11th June 2026

We would like to register our strong objection to Planning Application 2026/62/90880/E for the proposed redevelopment of the agricultural sheds at Liley Hall Farm into residential units.

BUILDING ONE
 PROPOSED GROUND FLOOR
 UNIT 1

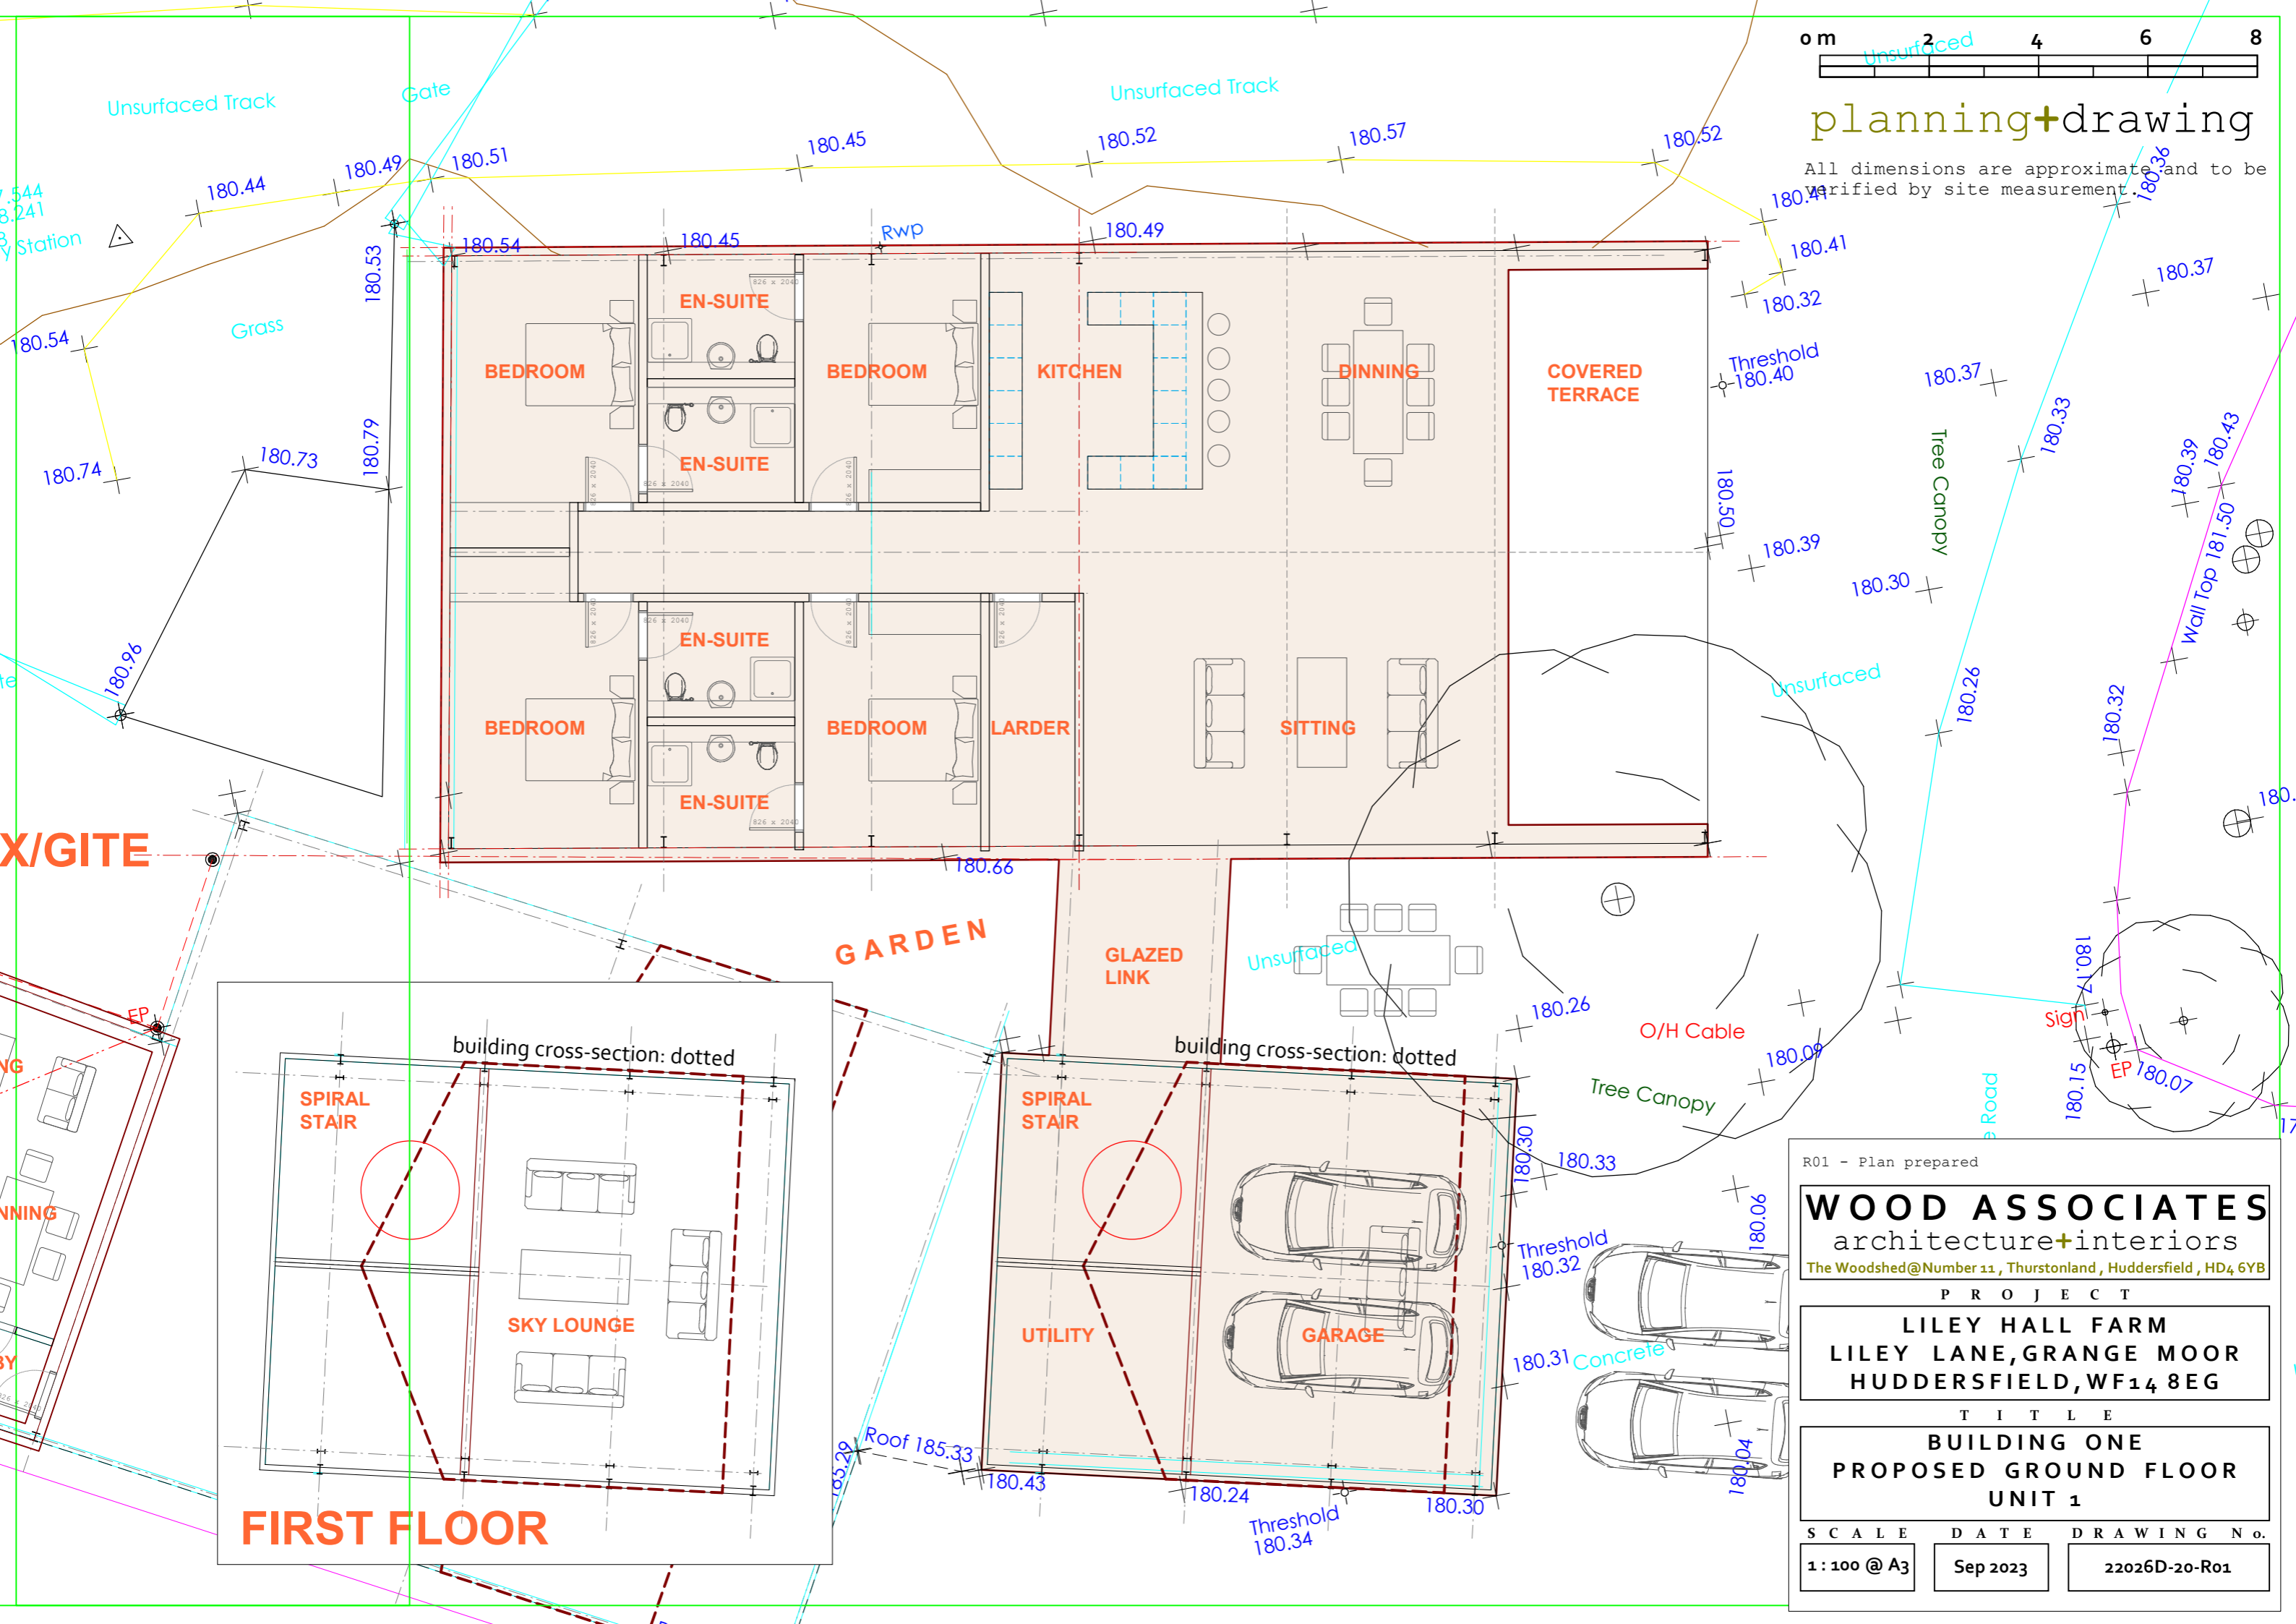
- **Existing Buildings 1-4 (Proposed Unit 1 + Annexe)**
 - Approximately 330sqm for the 5-bed house and 115sqm for the 2-bed annexe
 - Totalling approximately 445sqm (substantially greater than the 150sqm allowed)
- **Existing Building 5 (proposed units 2-4)**
 - Approximately 640sqm for the 3 new dwellings proposed (substantially greater than the 150sqm allowed)
- **Existing Building 6 & 7 (proposed units 5-9)**
 - Approximately 716sqm for the 5 new dwellings proposed (which, when taking into account first floor accommodation, would be *substantially* greater than the 150sqm allowance per unit)
- **Total Built Development Area approximately 1800 sqm**
 - Significantly exceeding the 1000sqm maximum that Class Q stipulates

T I T L E
EXISTING SITE /
BLOCK PLAN

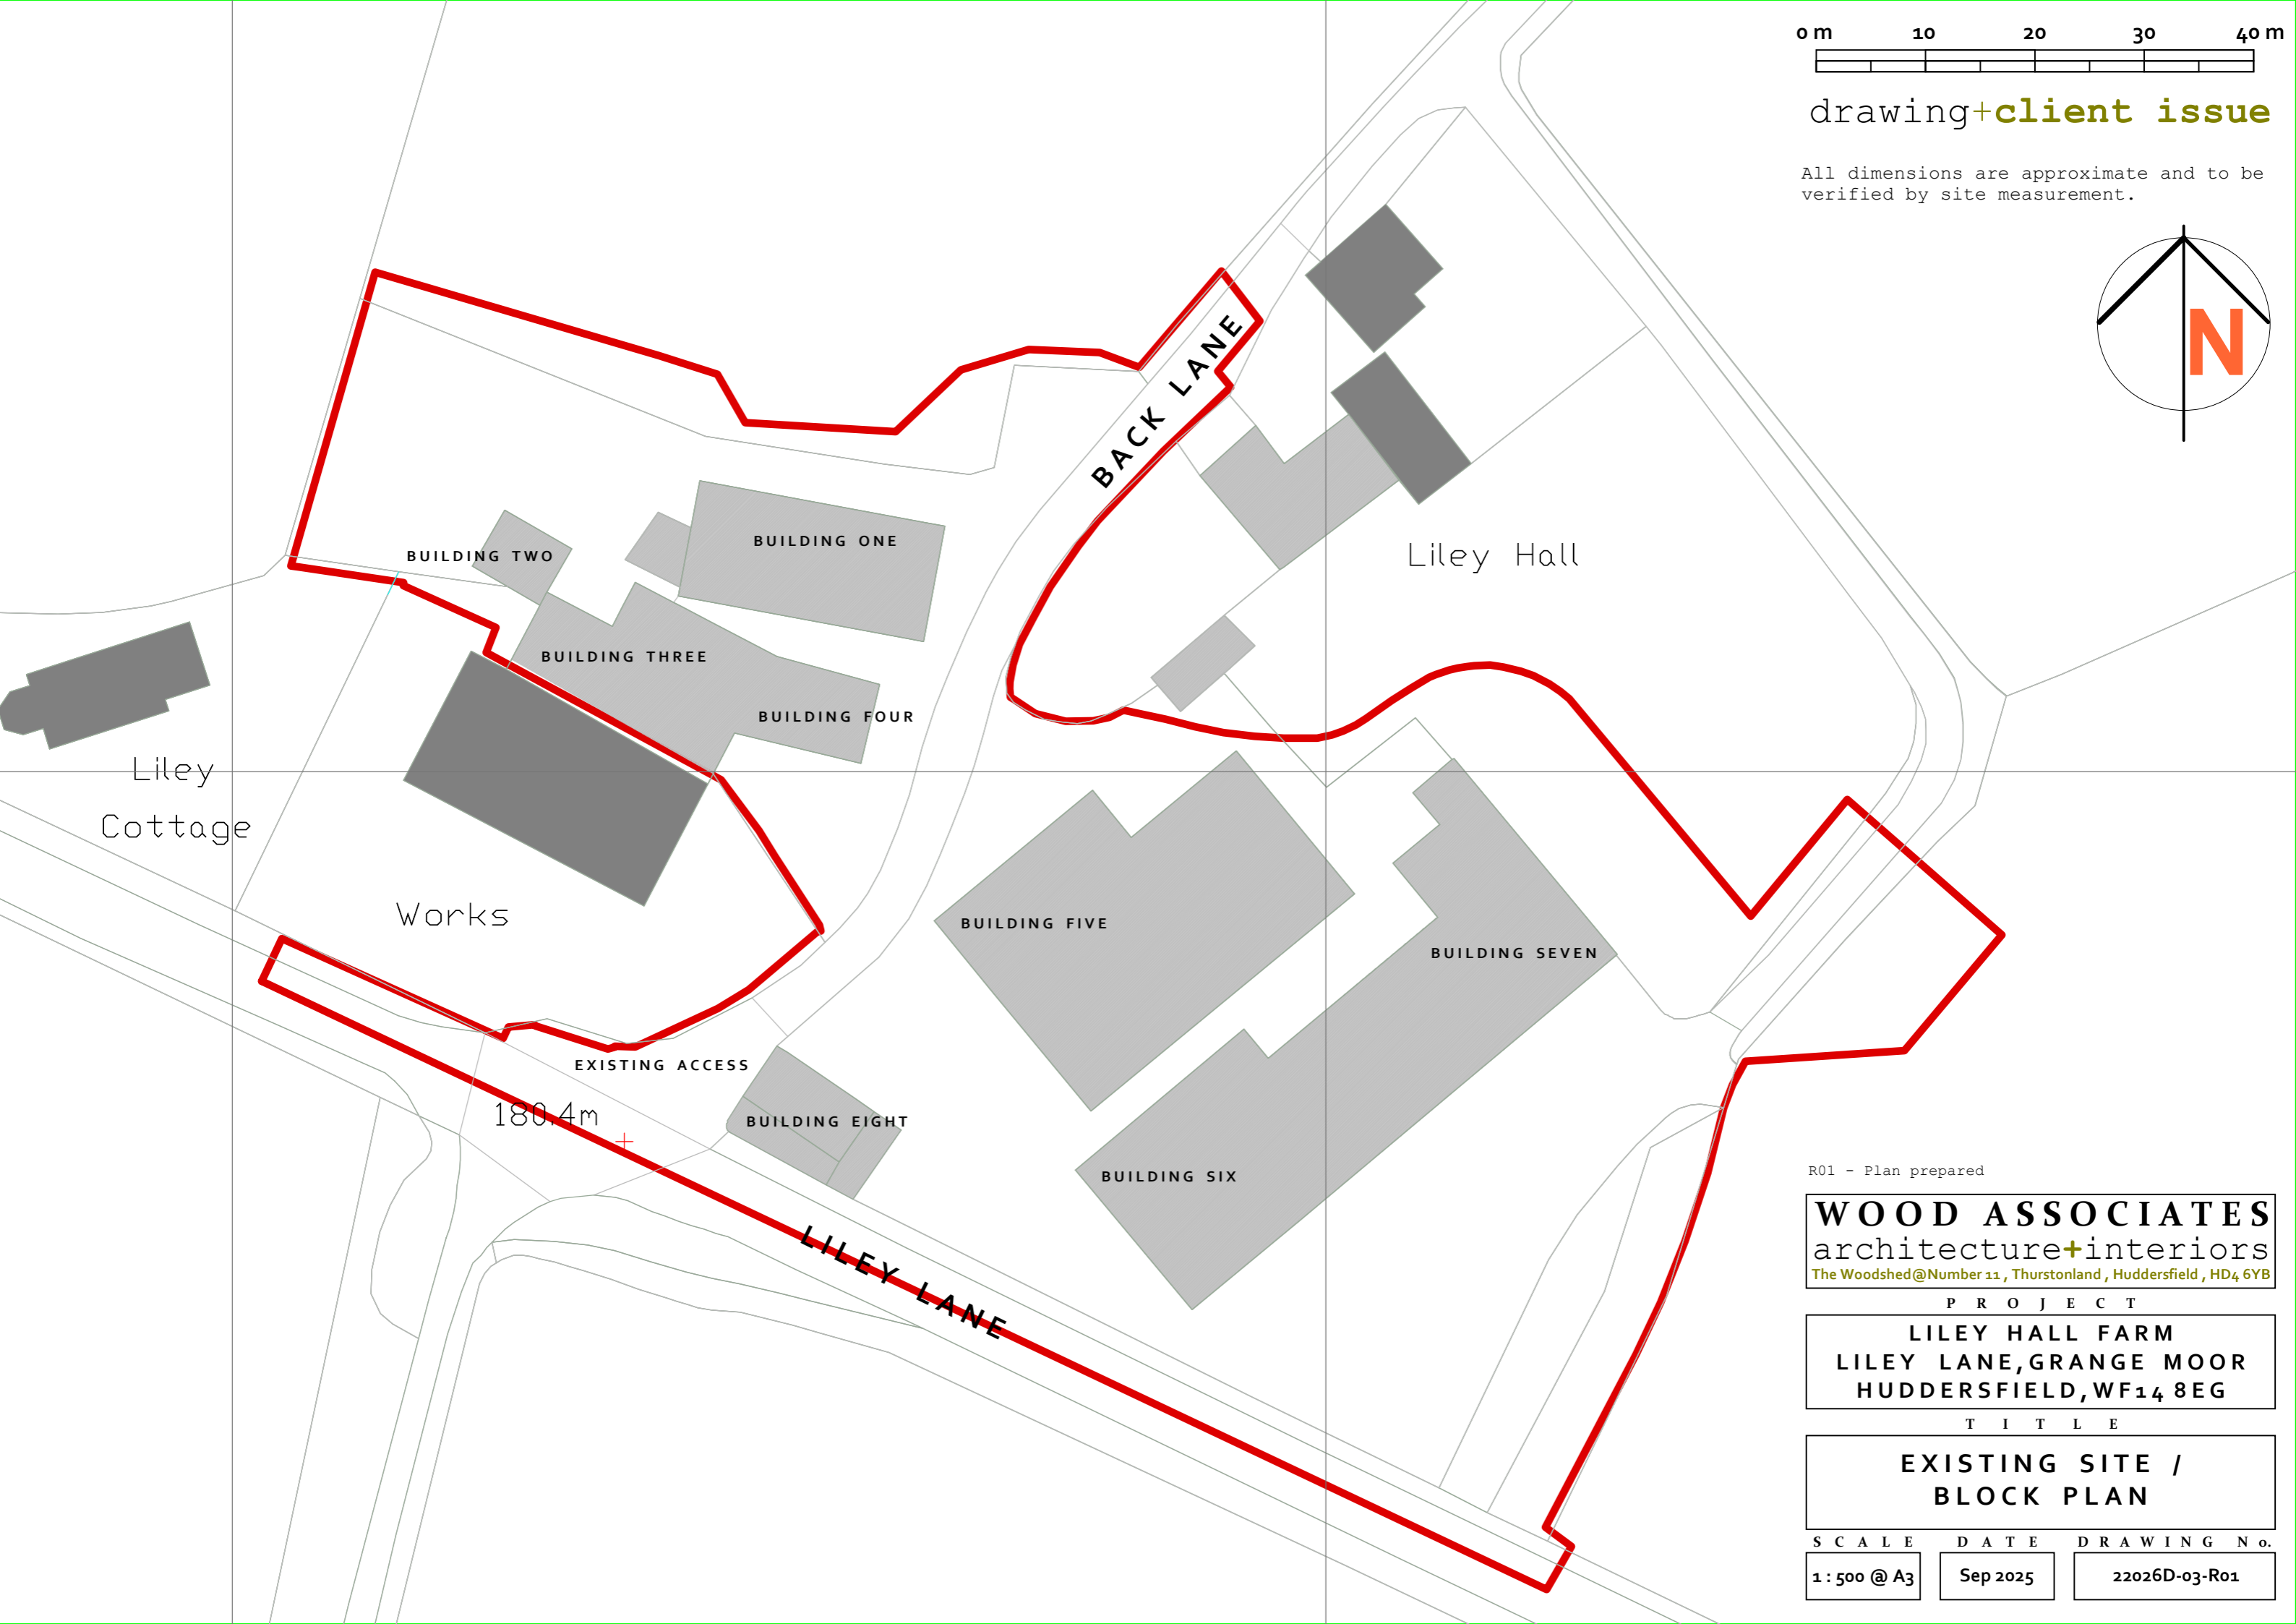
- It is also unclear from the information provided whether access is to be focused on the proposed new entranceway, which is less visible from the brow of the hill when approaching from the Mirfield end; or whether access is also to be made available through the existing gate marked 'existing field access' on the site plan.
